Application for Planning Permission for Works or Extension to a Dwelling

Development Extension to detached garage to form private fitness room and games room

Location 1 Aldwick Place Bognor Regis

BLOCK PLAN

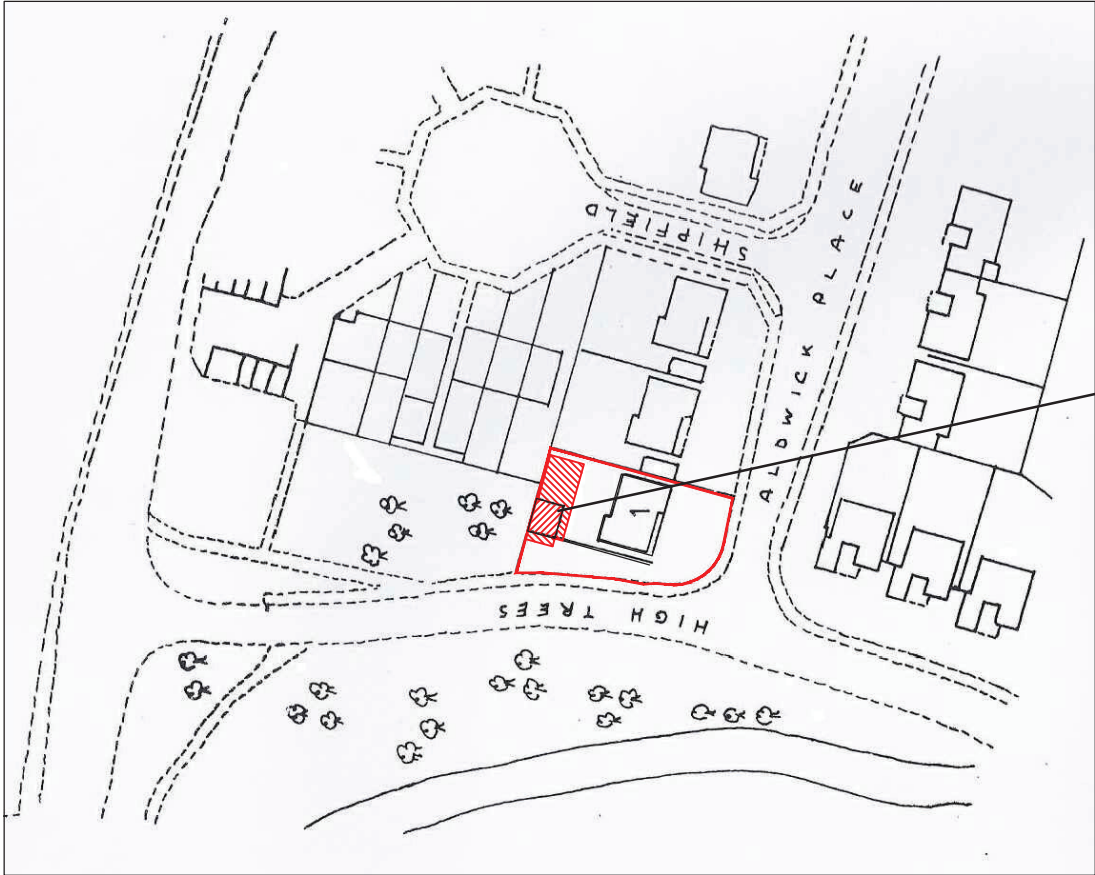
Please submit 1 electronic or 3 paper copies of a revised block/site plan with the proposed works clearly hatched in accordance with the guidance notes available on our website detailed below (click on National List). ✓
